Stage 1 Road Safety Audit: Road Safety Audit Response Report

Warwick Nursery

Eastergate

STAGE 1 ROAD SAFETY AUDIT

Access Drawing / Traffic Calming Measures / Visibility Splays

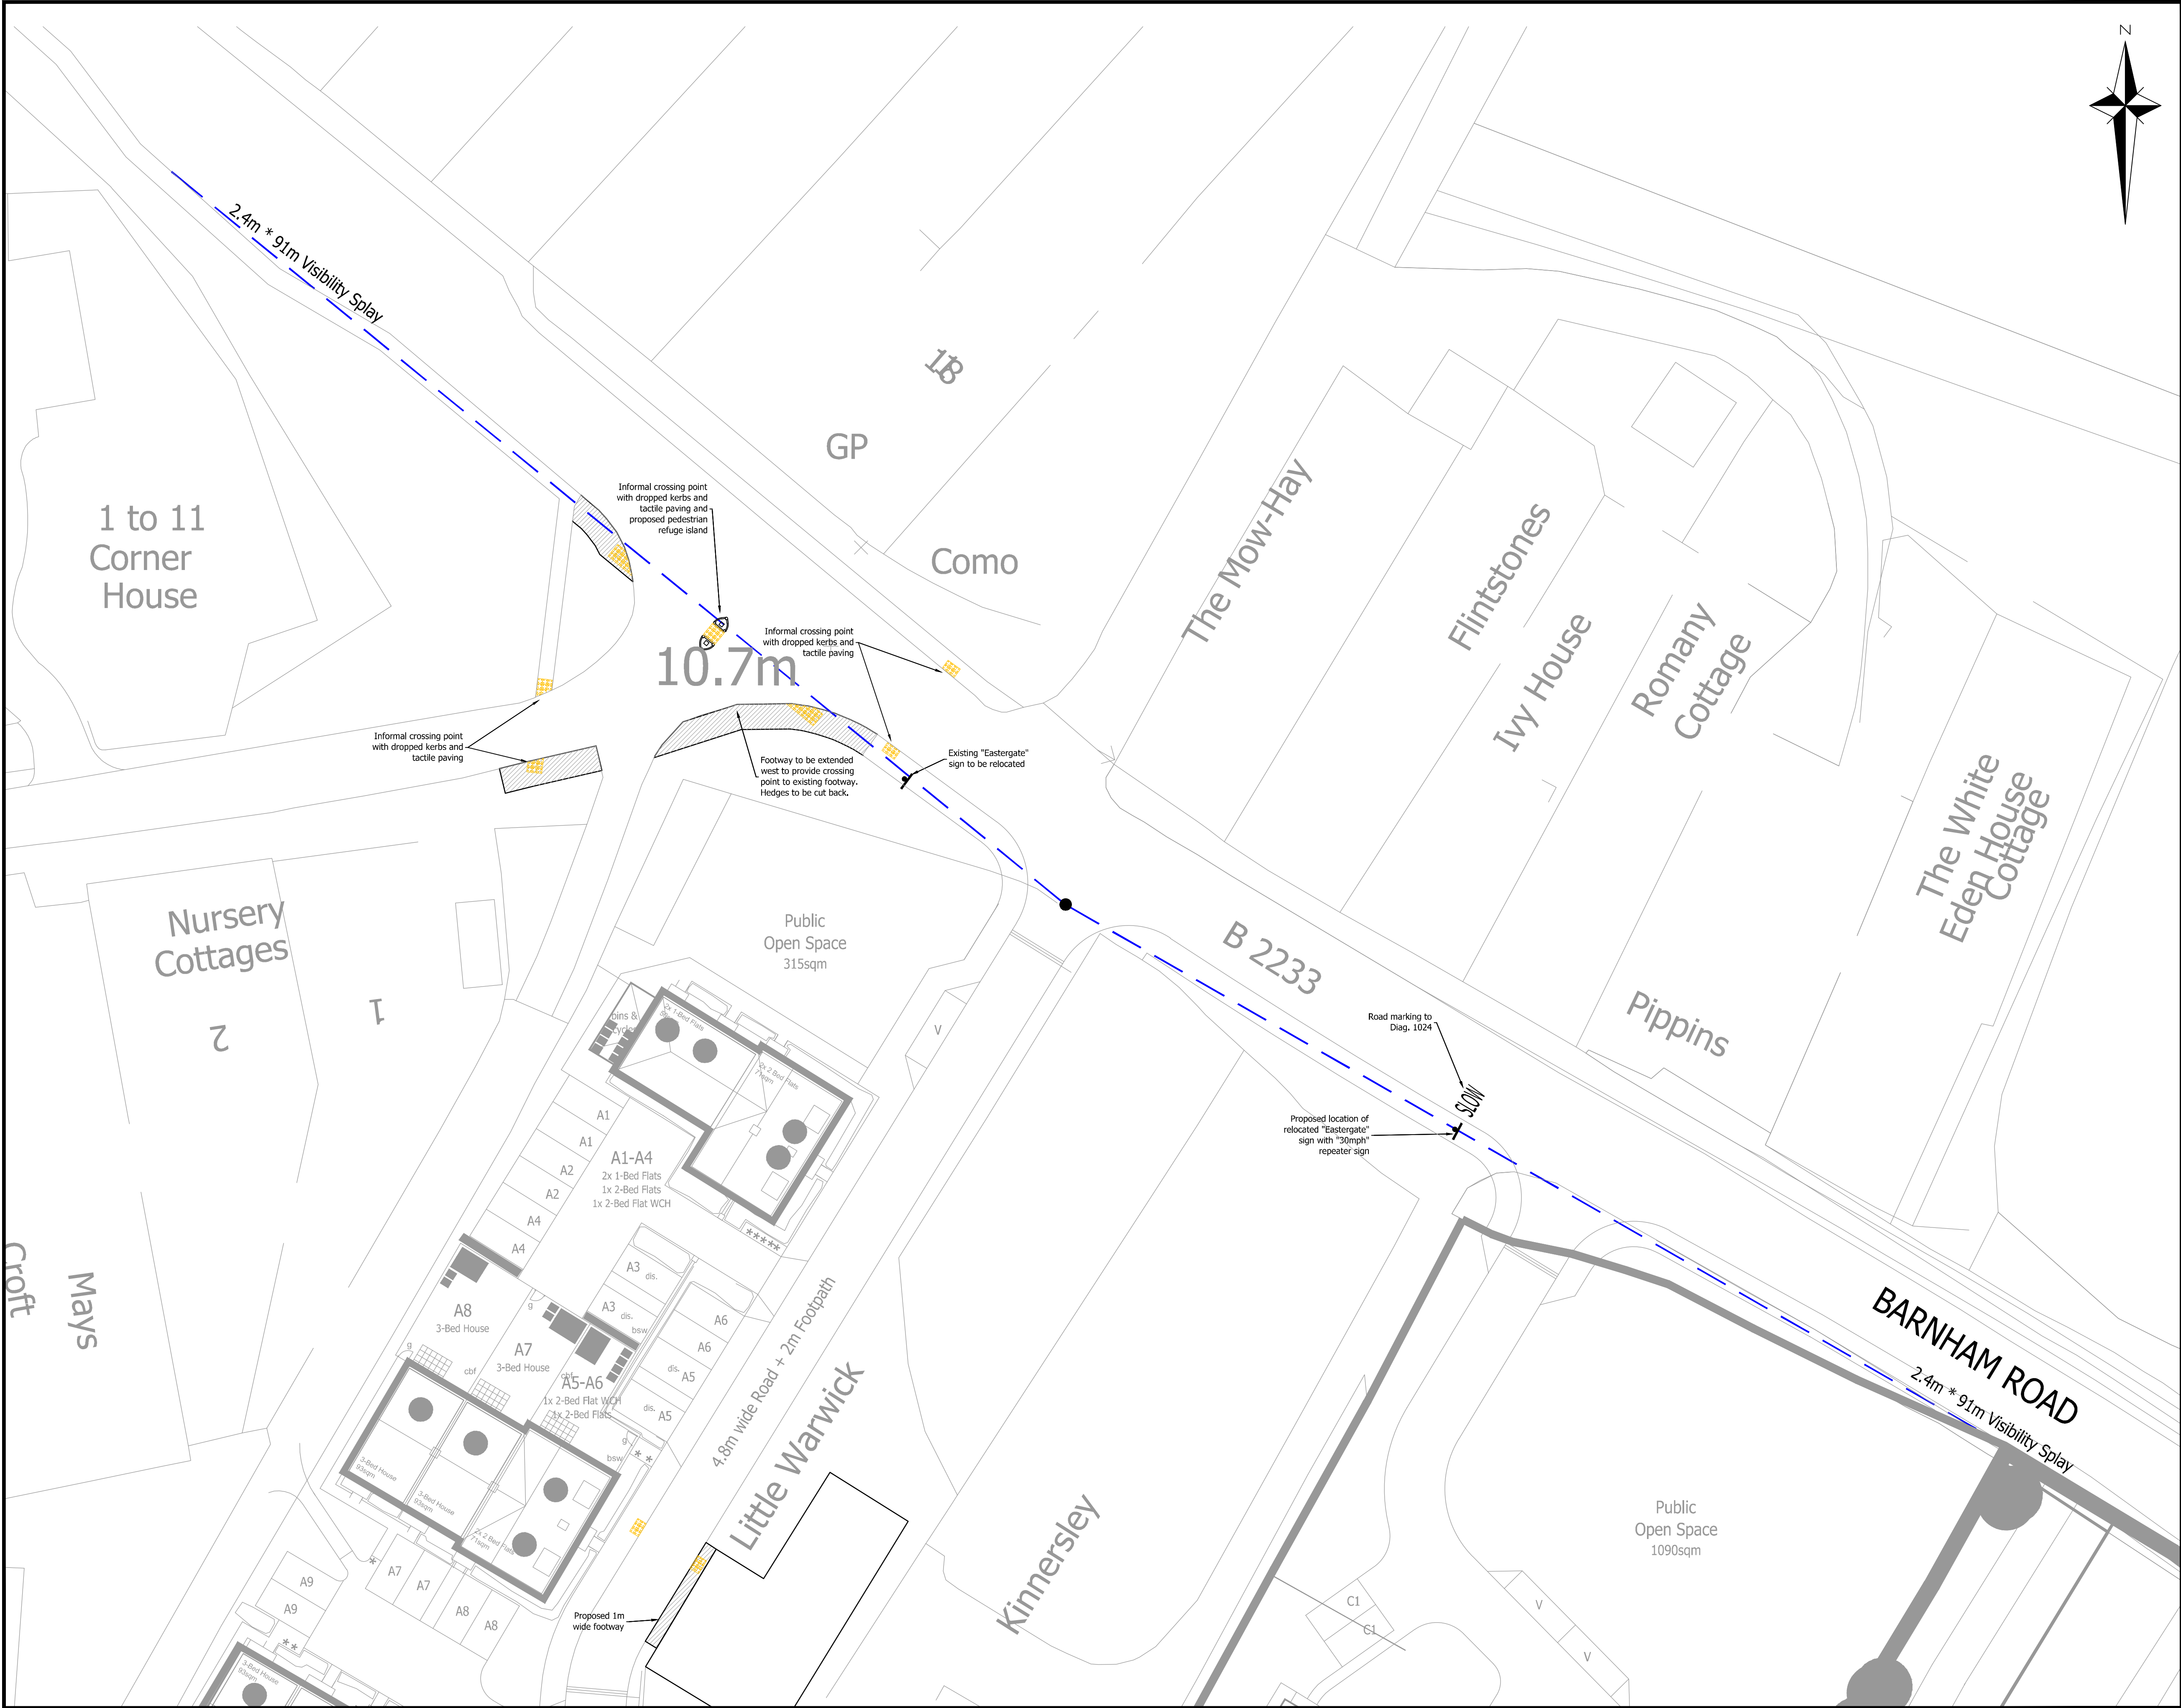
3.5.1 PROBLEM

Location: Church Lane junction with Barnham Road

Summary: Failure to give way collisions due to approach speed.

Detail: It is noted that the recent plan indicates that pedestrian improvements, including an informal crossing arrangement will be made to Church Lane. The existing refuge island at the junction is in a poor condition and not suitable for pedestrians to use, with no dropped kerbs or tactile paving and the proposed changes are welcome from a road safety point of view.

The original RSA highlighted that the proposed access and intensification of the site is going to result in an increase in turning movements both into and out of the site. The concern was that its proximity to the Church Lane junction could result in issues unless motorists are advised and encouraged to lower approach speeds. It is agreed that the Vehicle Activated Signs proposed, additional footway and refuge amendments will help to achieve this. However, additional warning close to the Church Lane junction would also be of benefit.

The SLOW markings on Barnham Road will help to warn drivers on the approach in each direction. However, an additional marking should be placed near the Church Lane junction to give additional information to drivers turning from Church Lane into Barnham Road.

Problem	Location	Description	Recommendation	Design Organisation Response	Overseeing Organisation Response	Agreed RSA Action
3.5.1	Church Lane junction with Barnham Road	Failure to give way collisions due to approach speed	The SLOW markings on Barnham Road will help to warn drivers on the approach in each direction. However, an additional SLOW marking should be placed near the Church Lane junction to give additional information to drivers turning from Church Lane into Barnham Road	Agreed. A 'SLOW' marking can be applied to Church Lane
